Schedule of Amendments

Project Mayfair on Penrith
Job No 6626
Revision 3
Date 18.05.2026

SSDA-1003

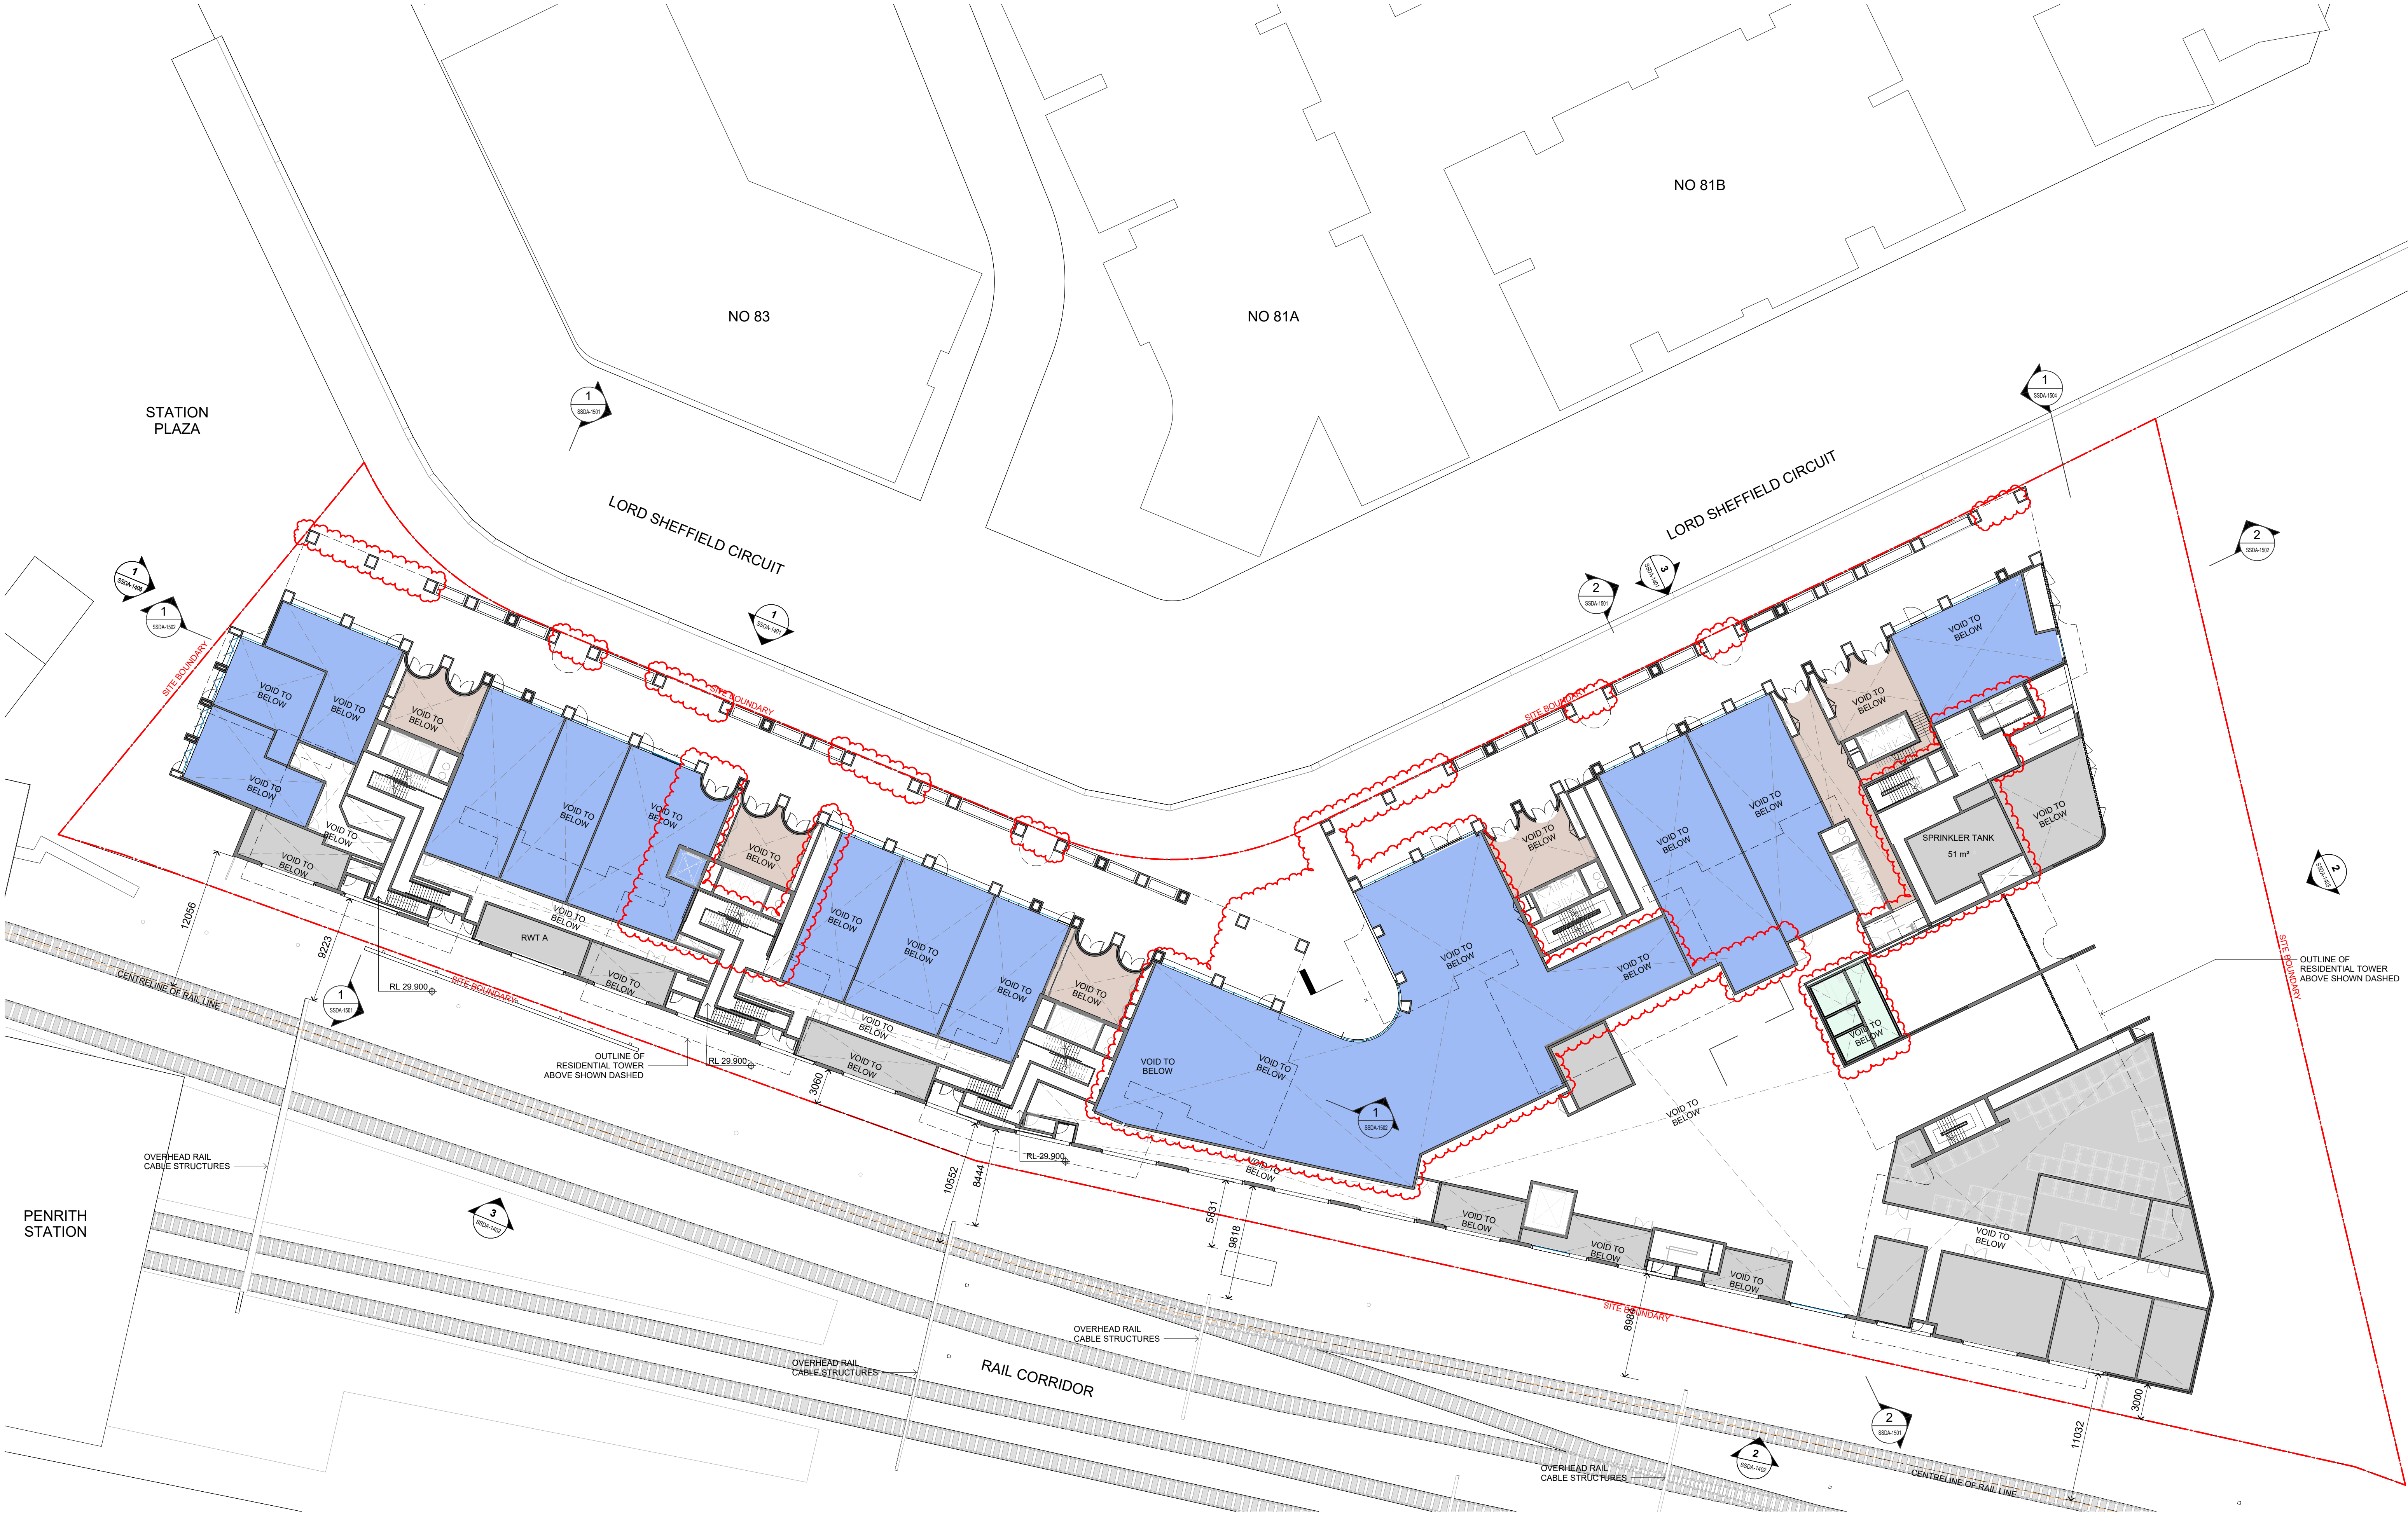
5	Ground Floor layout update	Relocated retail amenities on Ground Floor from Building 1 to Building 2. Revised tenancy areas due to shopfront adjustments. Residential lobby entries revised	SSDA-1003
6	Ground Floor colonnade updates	Building 1 colonnade circulation has been amended to provide compliant access across the entry driveway	SSDA-1003
7	Level 1 layout update	Revised design to Level 1 floorplate for commercial and retail tenancies. Amenities incorporated into tenancies. Adjustments to external glazing line & fire egress strategy	SSDA-1004
8	Changes to Community Forecourt outside Steakhouse tenancy	Ramp has been amended to 1 in 16 with increase outdoor seating, planter has been removed on Level 1 in the Community Forecourt, façade and planter layout changes	SSDA-1003
9	Reallocation of NDIS	Building 1 apartments have been reallocated to NDIS on Level 3-13. Apartment A313 has been reconfigured for compliance as carer's apartment.	SSDA-1006 SSDA-1007 SSDA-1009 SSDA-1010 SSDA-1011 SSDA-4411

SSDA-1011

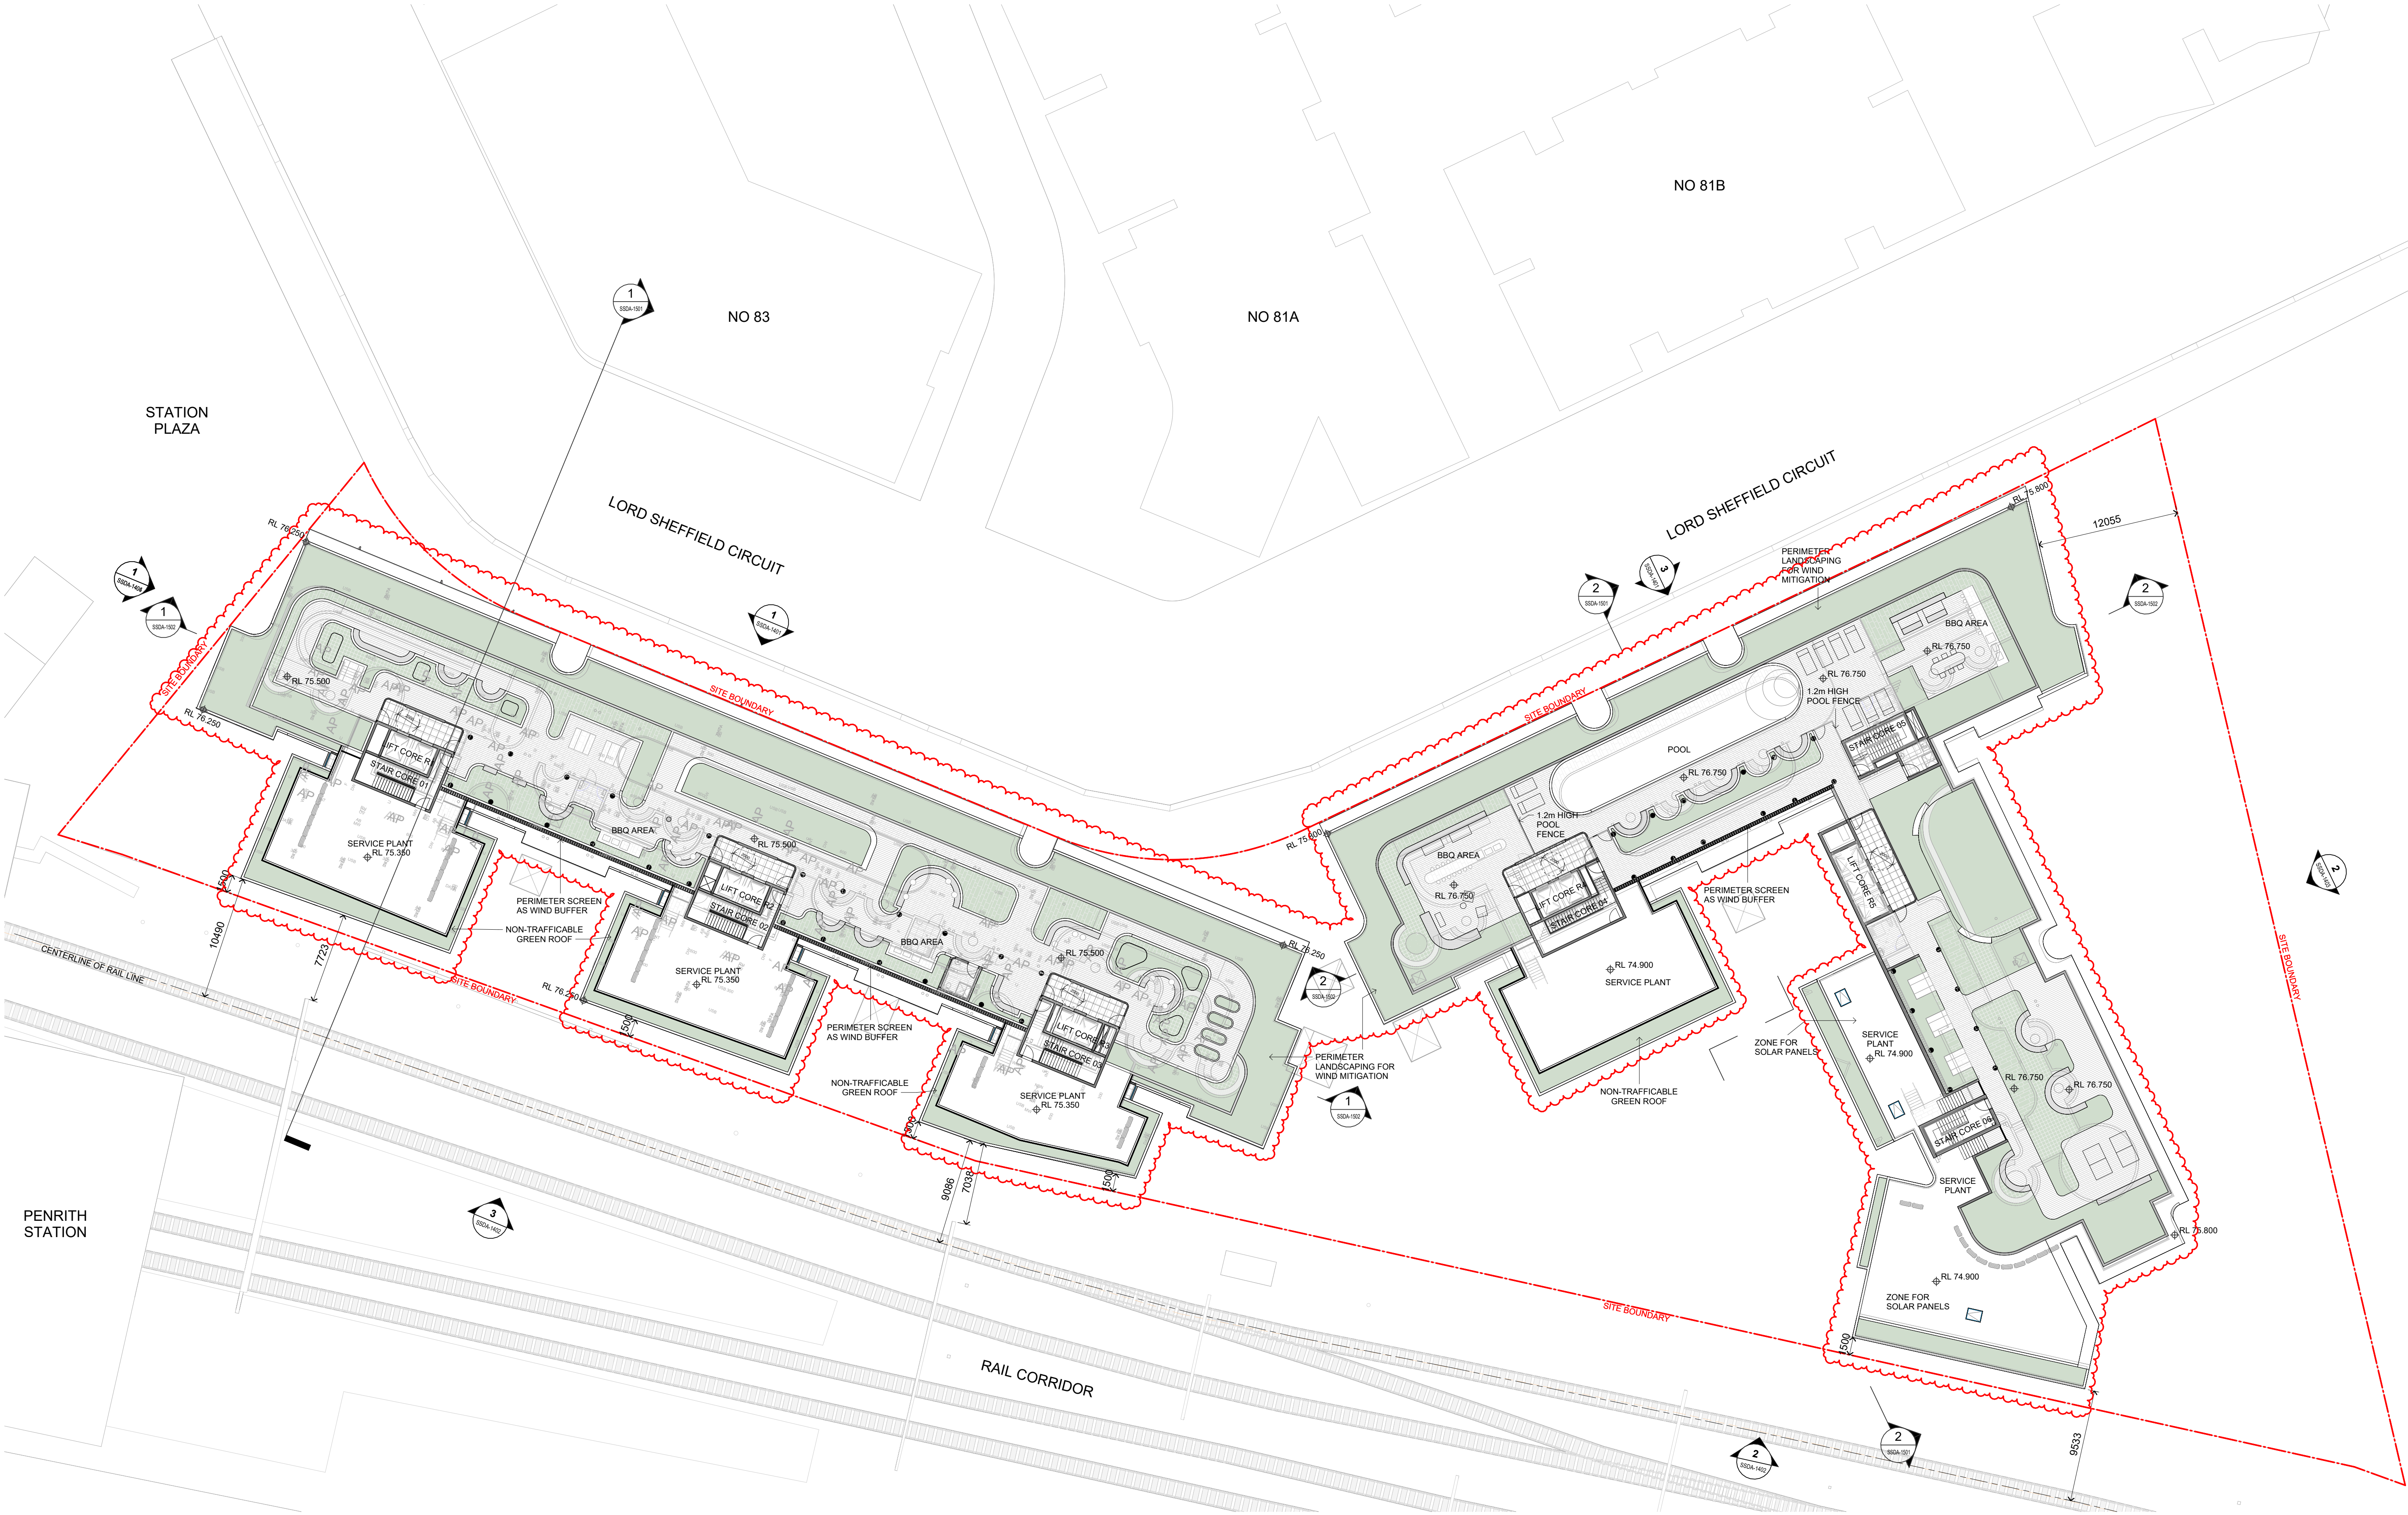
No.	Amendment	Description	Drawings
13	Internal layout amendments	Minor amendments to improve amenity	SSDA-1005 SSDA-1006 SSDA-1007 SSDA-1009 SSDA-1010 SSDA-1011 SSDA-4401 SSDA-4402 SSDA-4403 SSDA-4404 SSDA-4405
14	Traffic RFI Response	Updates to bicycle, car parking & storage cages to improve layout, usability & efficiency.	SSDA-0999 SSDA-1000 SSDA-1001 SSDA-1002
15	Façade Changes to NDIS apartments	Configuration of façade glazing updated to NDIS apartments to suit operator requirements	SSDA-1006 SSDA-1007 SSDA-1009 SSDA-1010 SSDA-1401 SSDA-1402 SSDA-4411 SSDA-4412
16	GFA & Affordable Housing Area	GFA & Affordable Housing GFA diagrams updated to include wintergardens on Level 2 and extension of corridors	SSDA-6101 SSDA-6102 SSDA-6103 SSDA-6105

SSDA-1401

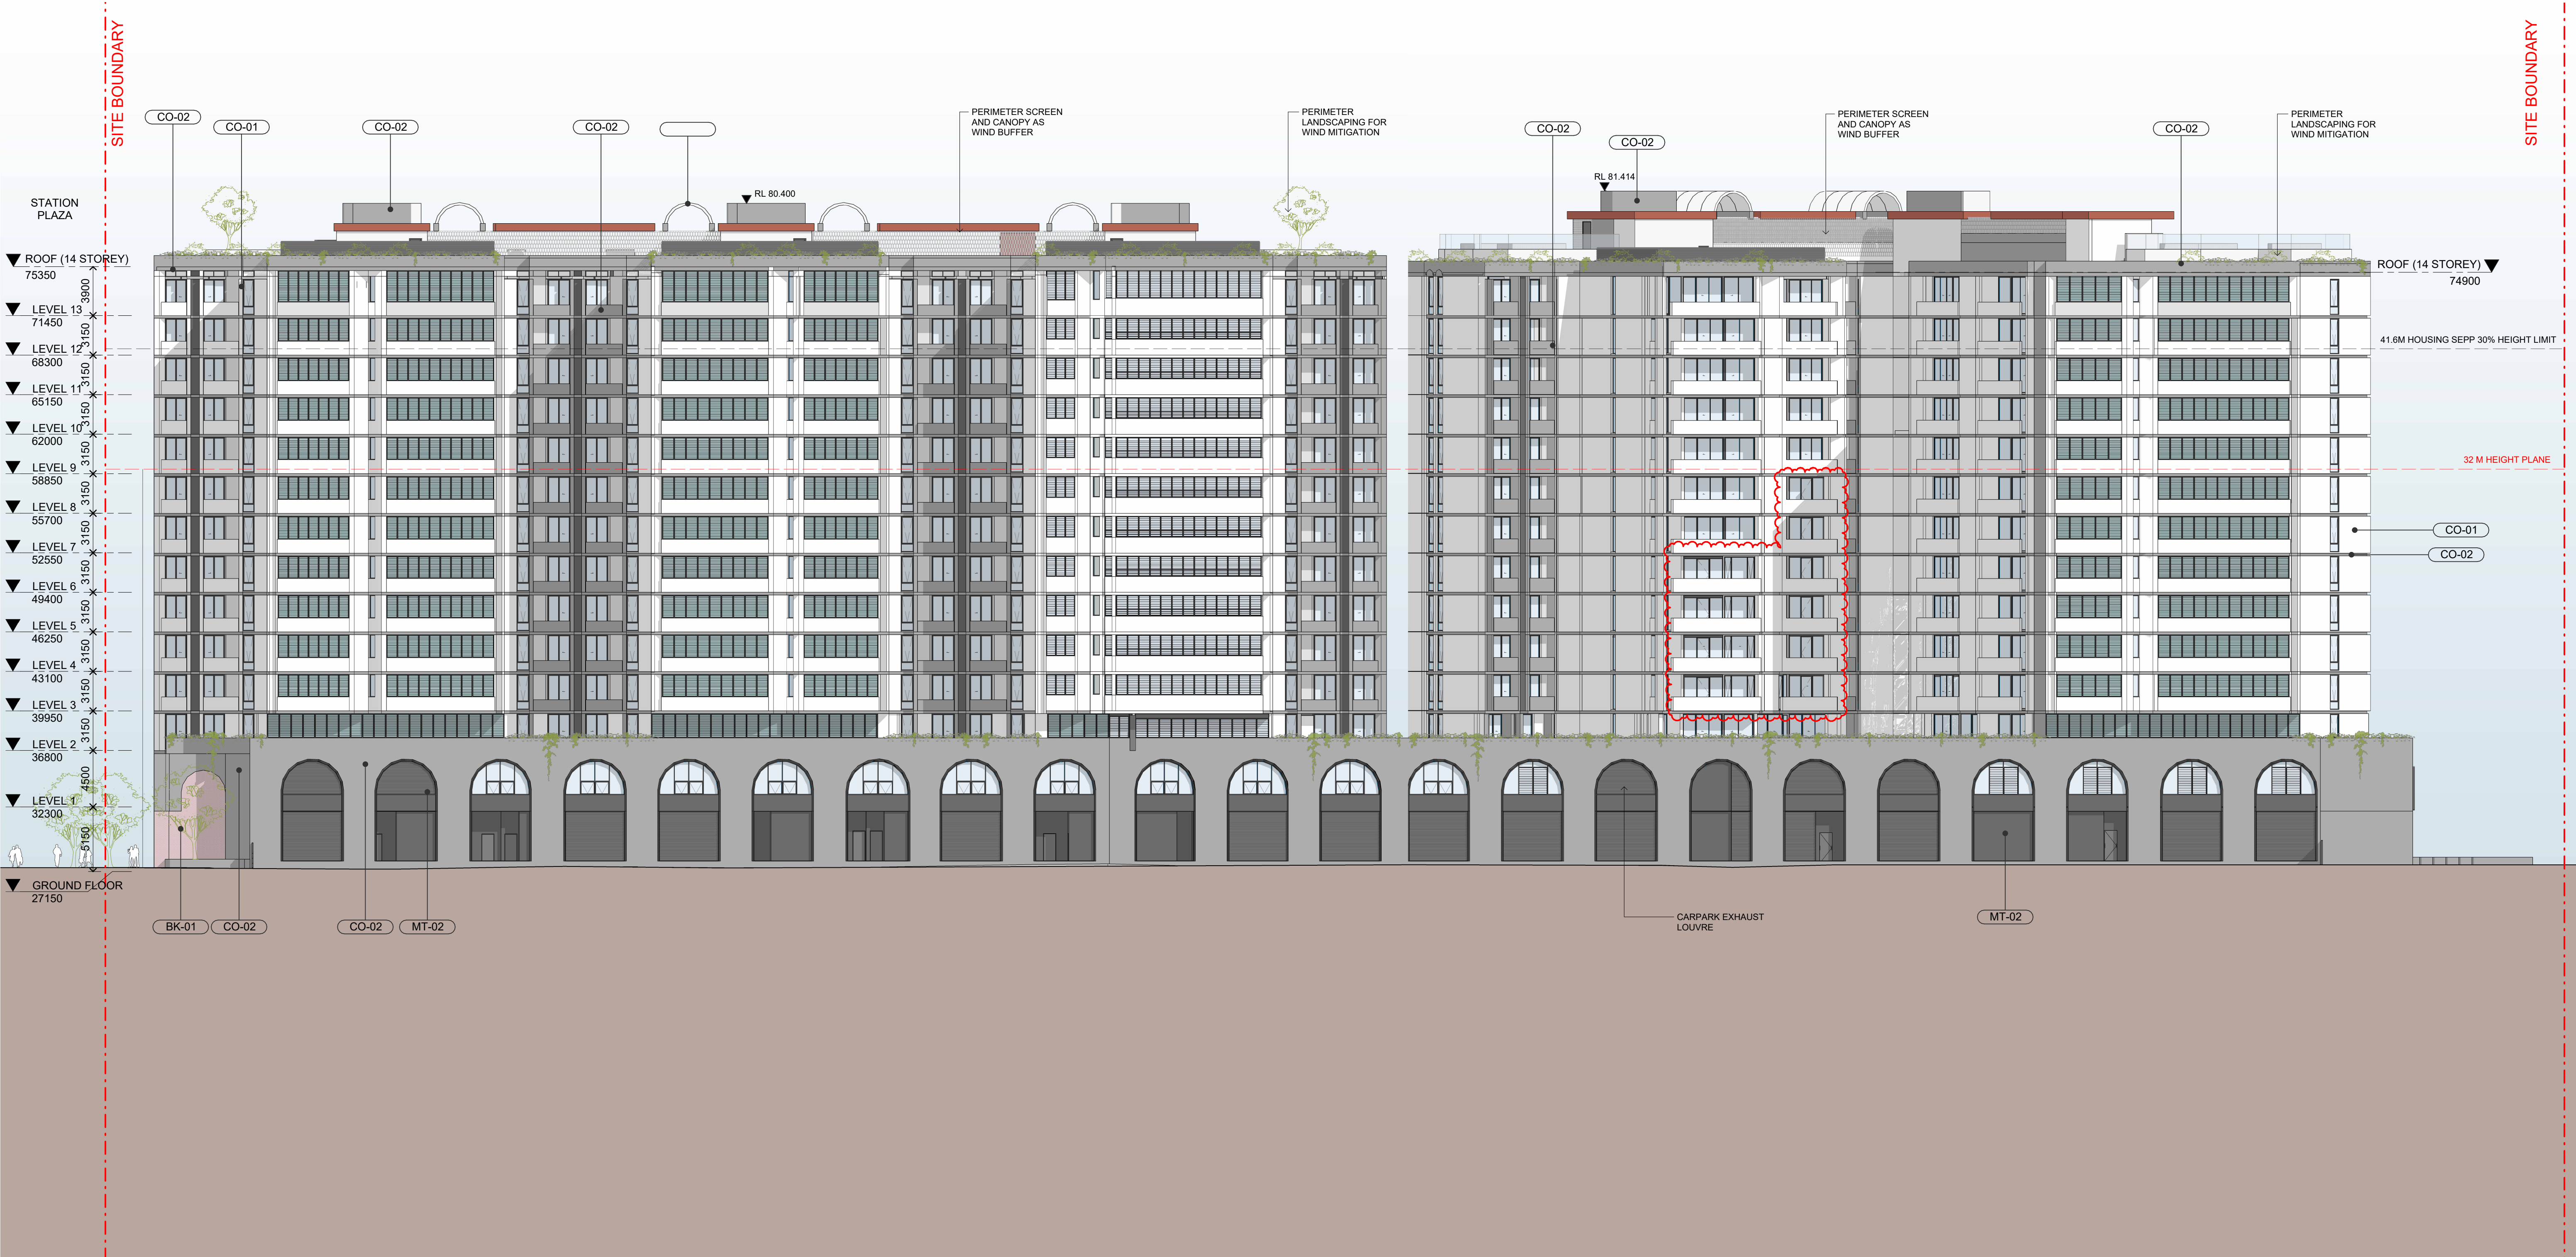
10	Level 2 southern balcony changes	Structural blade walls to south elevation have been included on balconies	SSDA-1005
11	East elevation updates	Removal of brick to Ground Floor façade, fin profile has been squared in the tower and corbel form has been amended beneath A304 apartment.	SSDA-1006 SSDA-1007 SSDA-1009 SSDA-1010 SSDA-1011 SSDA-1403
12	Planters removed	Level 1 planters removed along north elevation to larger arches and below scooped forms	SSDA-1004 SSDA-1401
